From: Gomez, Angela J.
Sent: Tuesday, August 04, 2020 2:02 PM
To: Gomez, Angela J.
Subject: FW: [#2020013] Wintergreen Apartments DRB questions (PR-2020-004030)

From: Richard Stevenson [mailto:rstevenson@tierrawestllc.com]
Sent: Tuesday, August 04, 2020 1:55 PM
To: Marsha Kearney
Cc: p crump; Ron Bohannan; rick@rba81.com; gnh5976@gmail.com; 1garciagang@gmail.com; mdmiraba@msn.com; meganfitz@live.com; bcreel@msn.com; frandimarco@msn.com; cfmirabal@gmail.com; ruffkat@yahoo.com; david.m.lopez@msn.com; garnand_lu@yahoo.com; kmcvey124@comcast.net; tjmurieta@msn.com; nenaperkin@gmail.com; avalgman12@gmail.com; scott.templeton@comcast.net; chavezdyx4@yahoo.com; mccormackdj@comcast.net; erin.coffman@yahoo.com; huerta.loretta58@gmail.com; gayle.binkley@me.com; marshakearney@gmail.com; nauticalhutch@gmail.com; miladybutler@yahoo.com; rfasel@fed.net; Gomez, Angela J.; Wolfenbarger, Jeanne; Gould, Maggie S.
Subject: RE: [#2020013] Wintergreen Apartments DRB questions (PR-2020-004030)

The intent of this email is to provide responses to the questions raised by neighbors at the DRB hearing on July 22nd 2020, in regards to the proposed Wintergreen Apartment project City project number PR-2020-00

SECTION 1

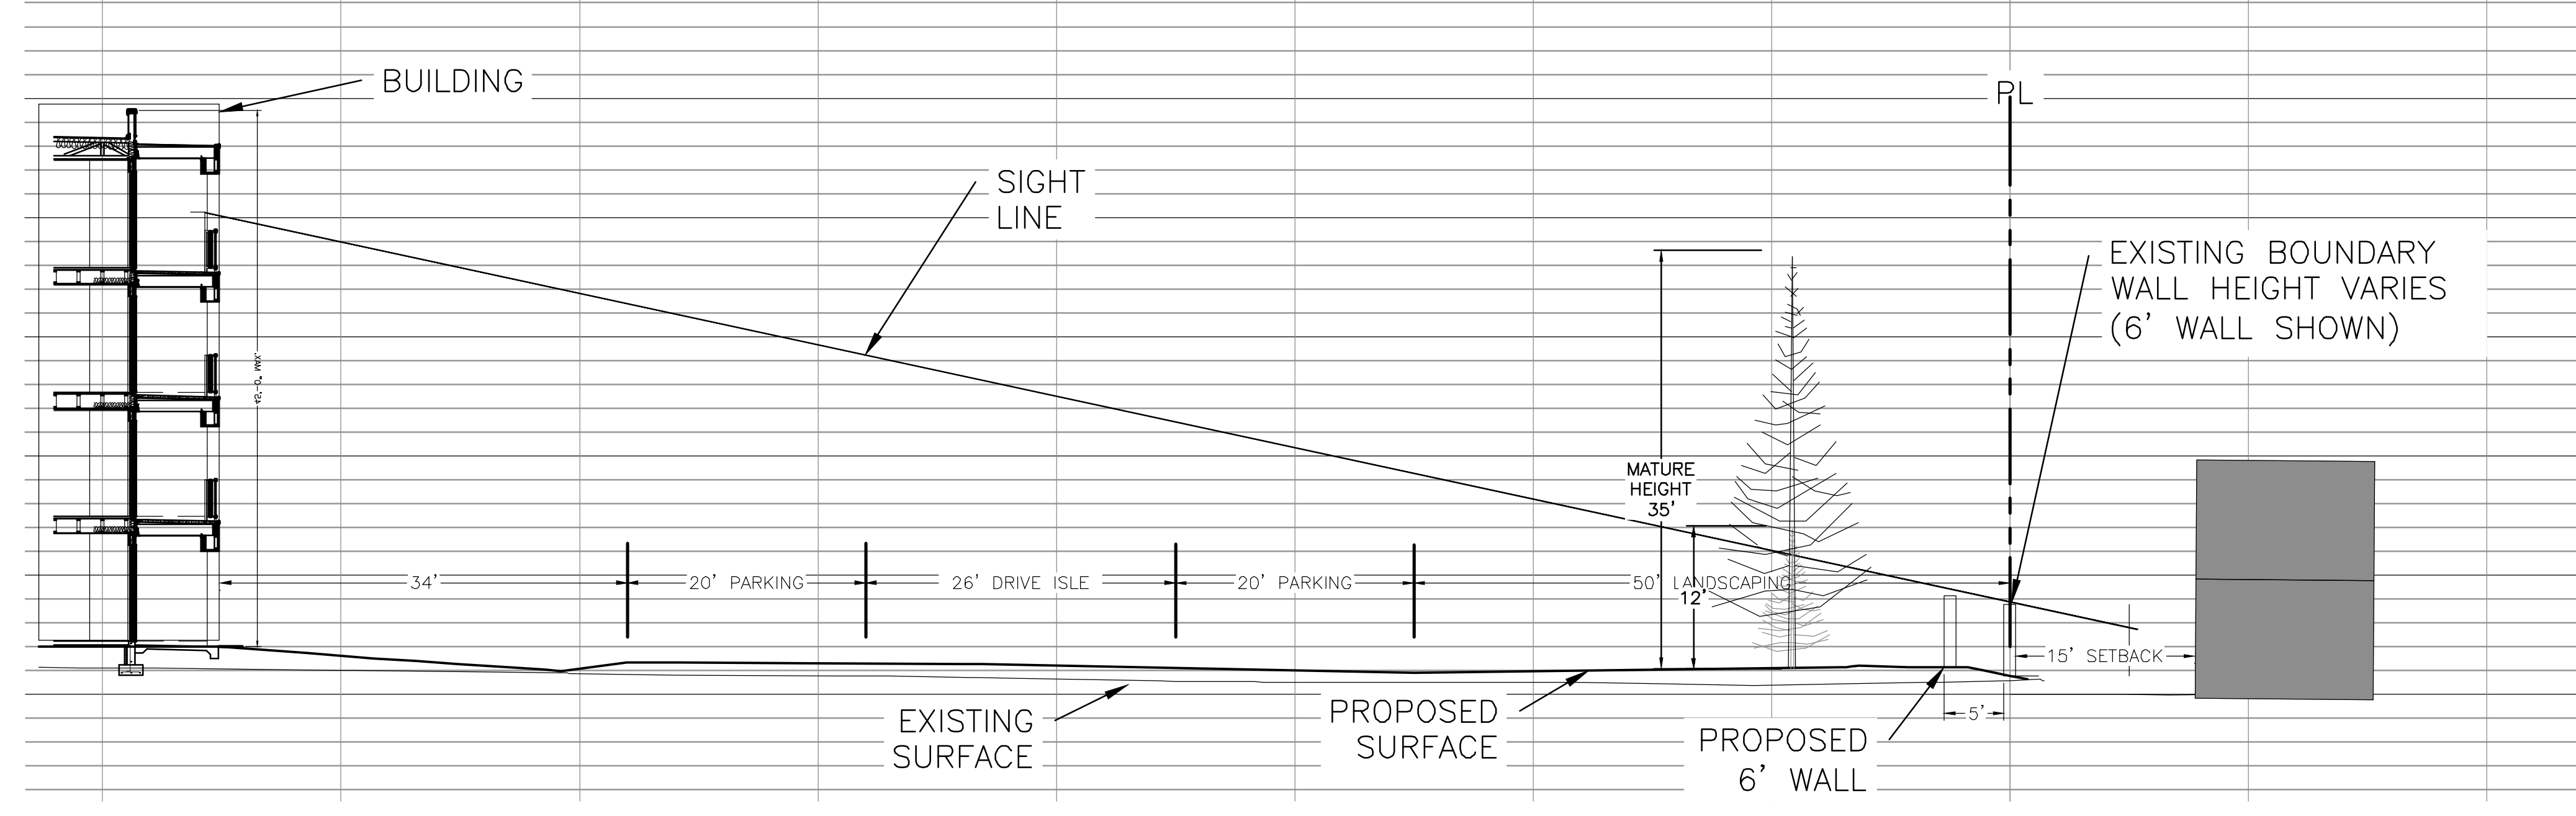
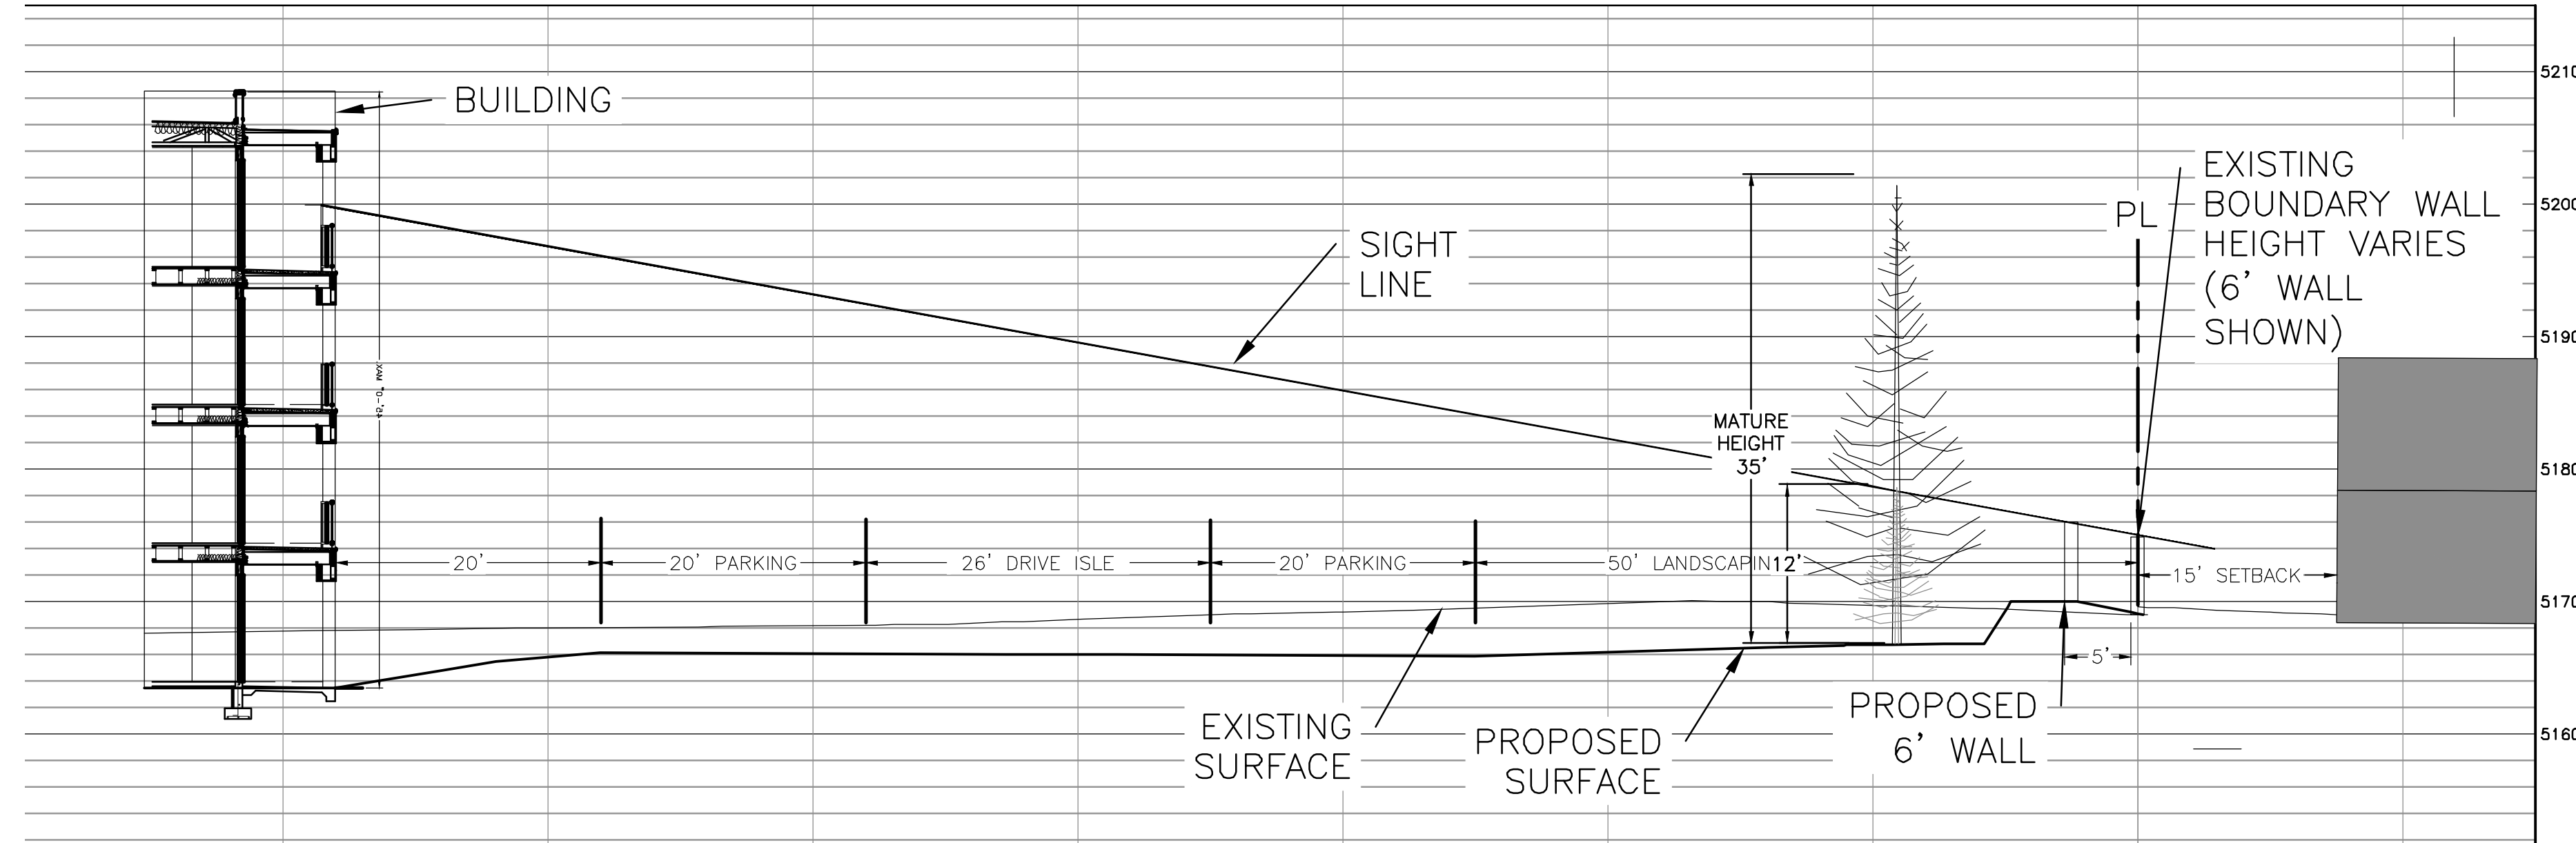
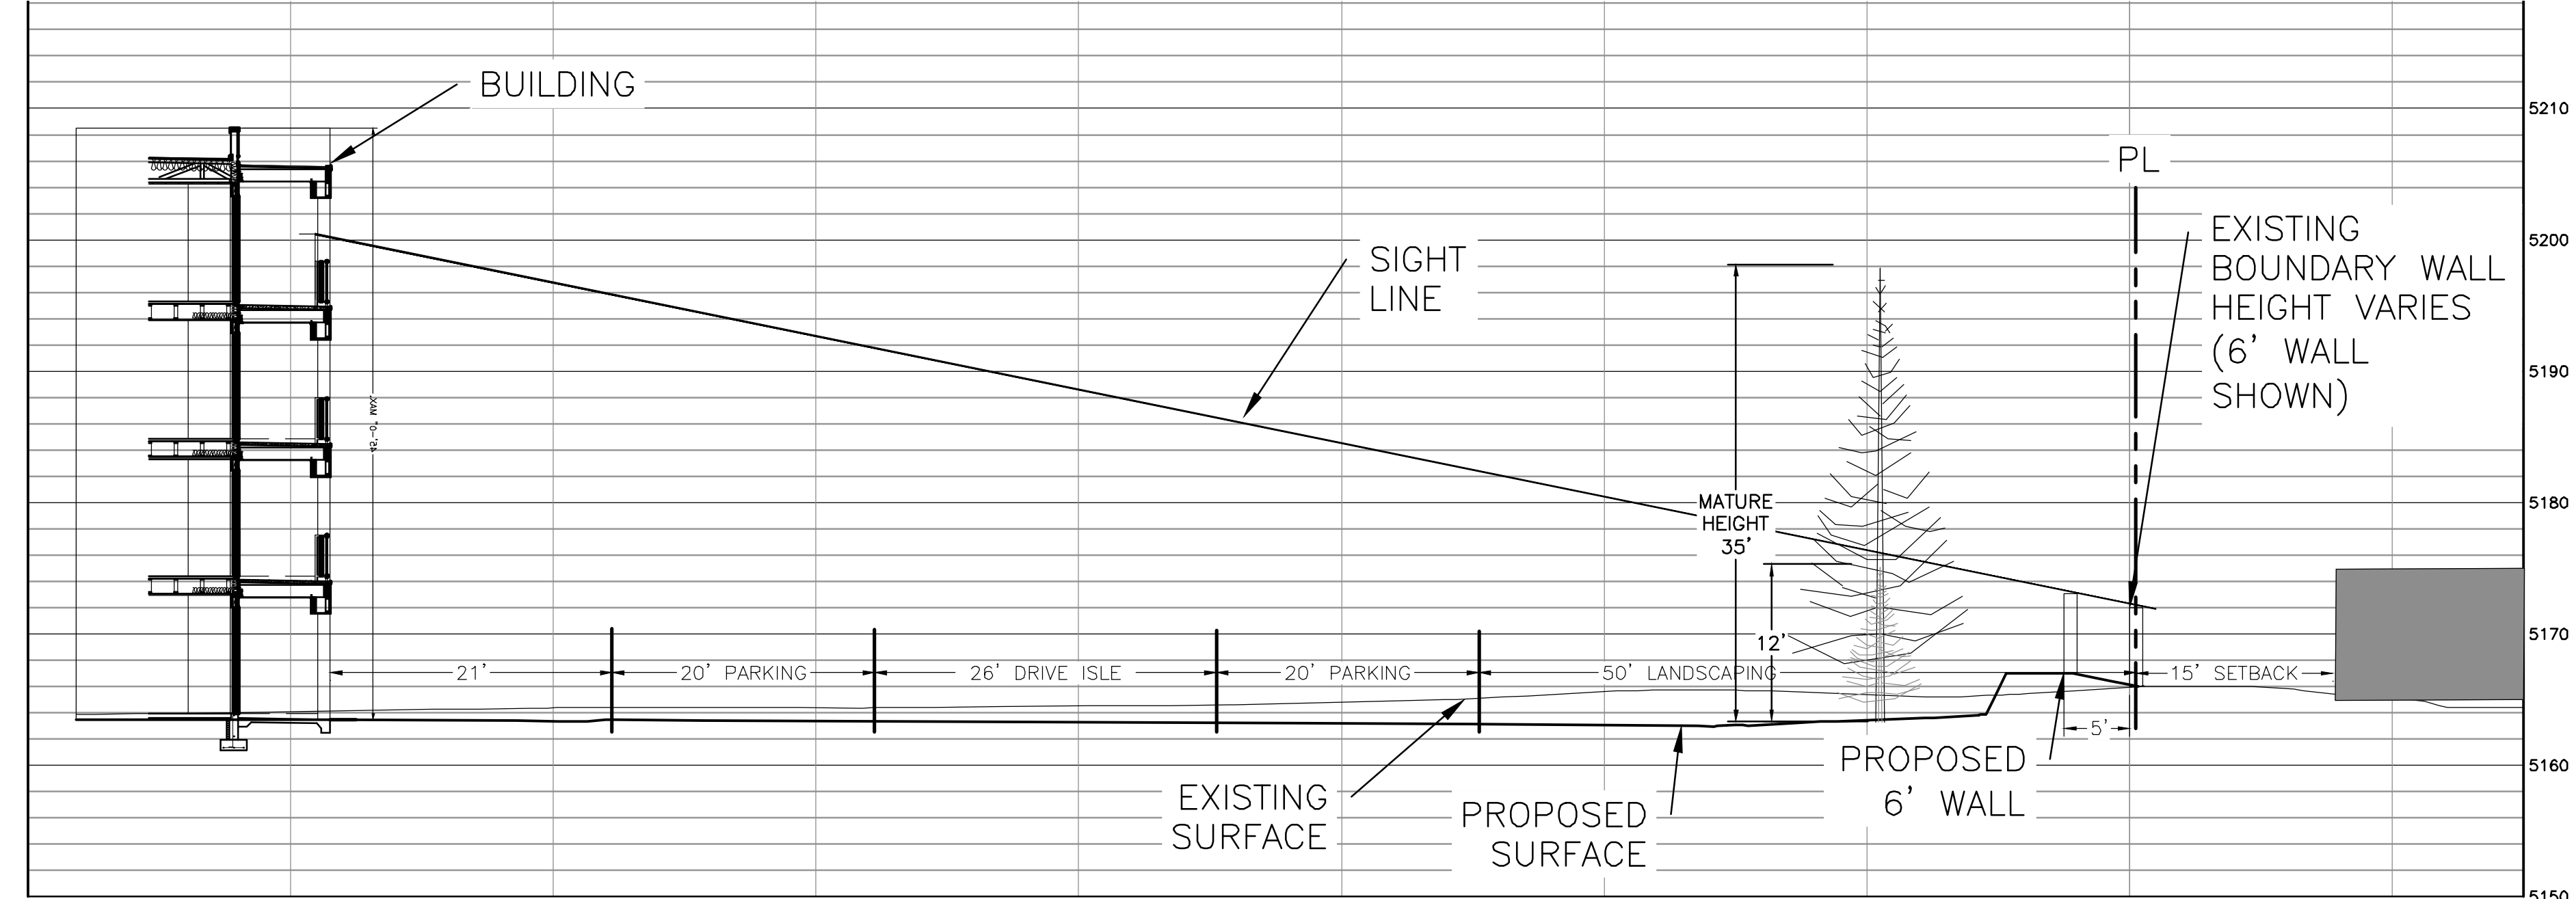
7. The cross-sections provided are inadequate when speaking to the privacy and noise barriers needed for the residents. Cross-sections show trees. Where exactly are they planted, spacing, heights, etc. We have no clear view of what will be in the buffer and how it will protect the adjacent property owners.

The tree sizes at planting and at maturity are shown in the cross sections to provide a scale and orientation of the apartment building relative to the single family homes and detail the buffer area. As previously mentioned the IDO requires a 50-ft landscape buffer (IDO Section 5-9(F)) to provide a setback between the improvements and the single family homes to increase the privacy and to reduce sight-lines from adjoining properties. Based on the proposed building height there is also a minimum 100-ft offset from the property line (IDO Section 2-4(C)), to provide protection to the adjacent home owners. Please refer to the landscaping plan which details the tree spacing, heights at maturity etc. which is included in the plans (link provided in previous email).
